Application no: H13/0644/98

Description: 4/5 bedroom house and garage

Location: The Sidings (Plot 11)
Moulton
Spalding
Lincolnshire

TOWN AND COUNTRY PLANNING ACT 1990
NOTICE OF ACCEPTANCE OF AMENDMENT

DRAWING No.:
DGM-M.23

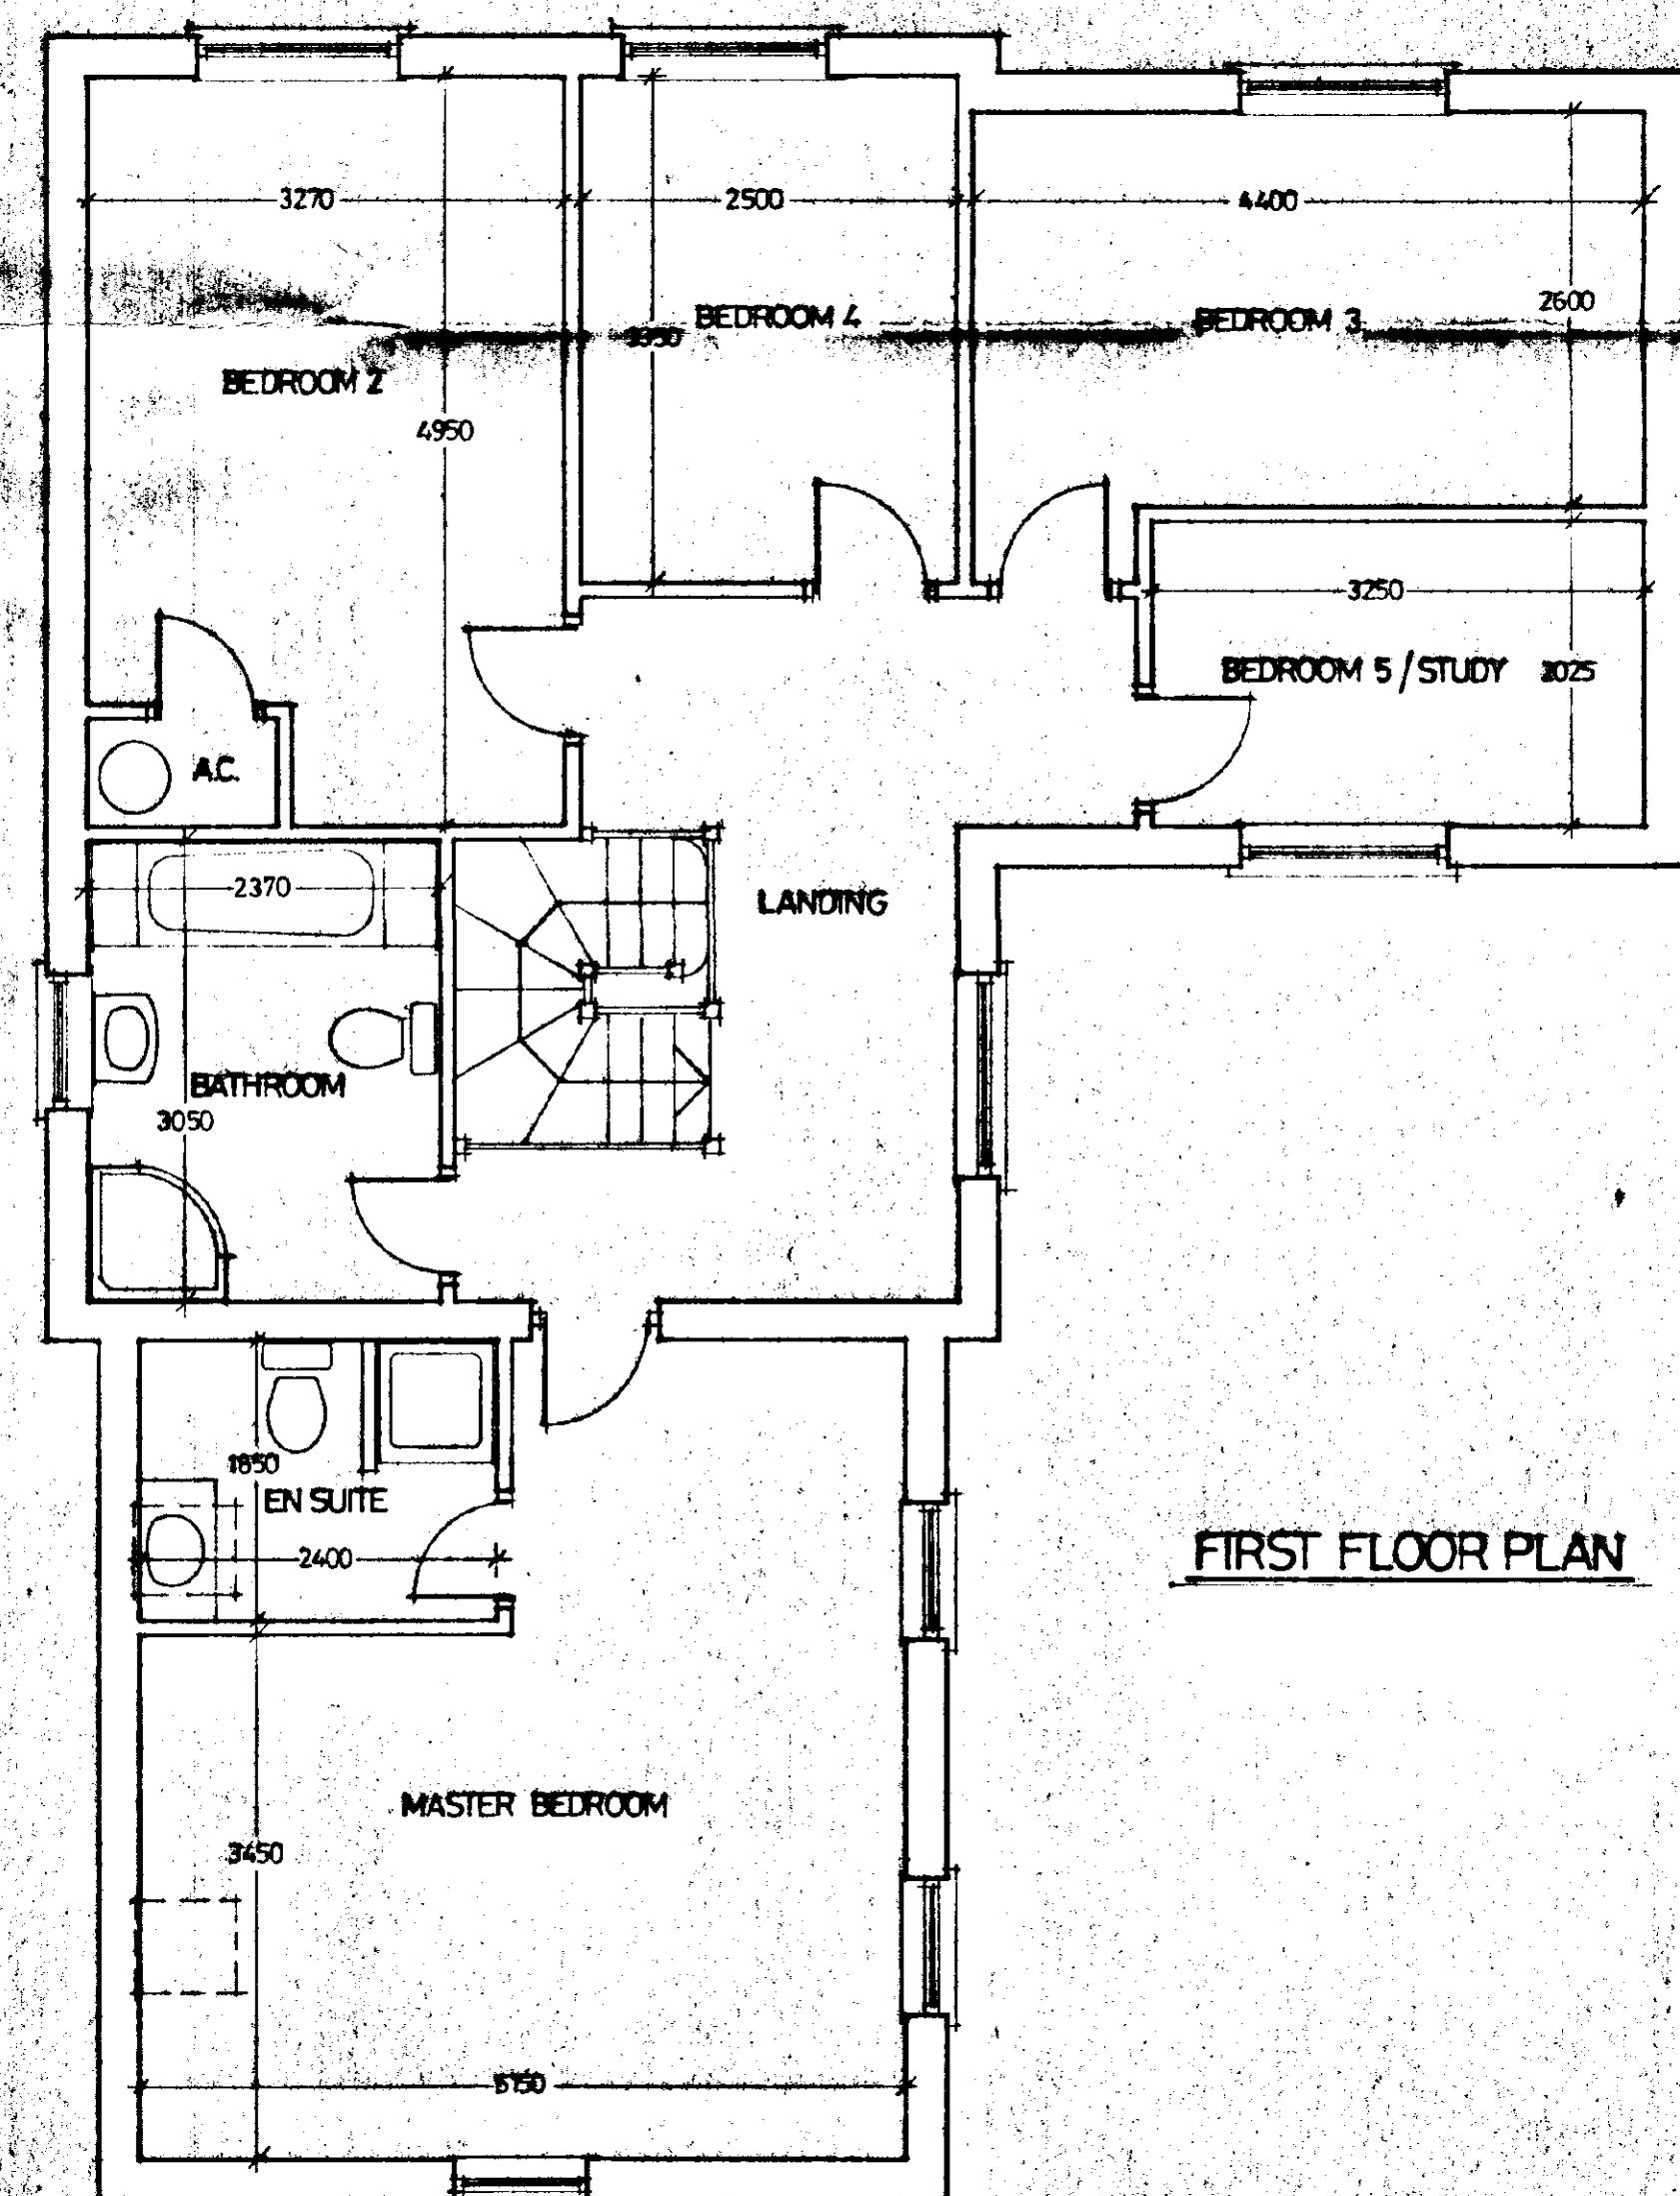
Amendment: Change one garage into playroom
(dwg no. DGM-M.23B)

CHANGE ONE OF THE GARAGES INTO PLAYROOM AS REQUESTED BY THE PURCHASER.

The amended details submitted in respect of the above proposal have now been considered and there are no objections to the amendment being implemented to the extent described above.
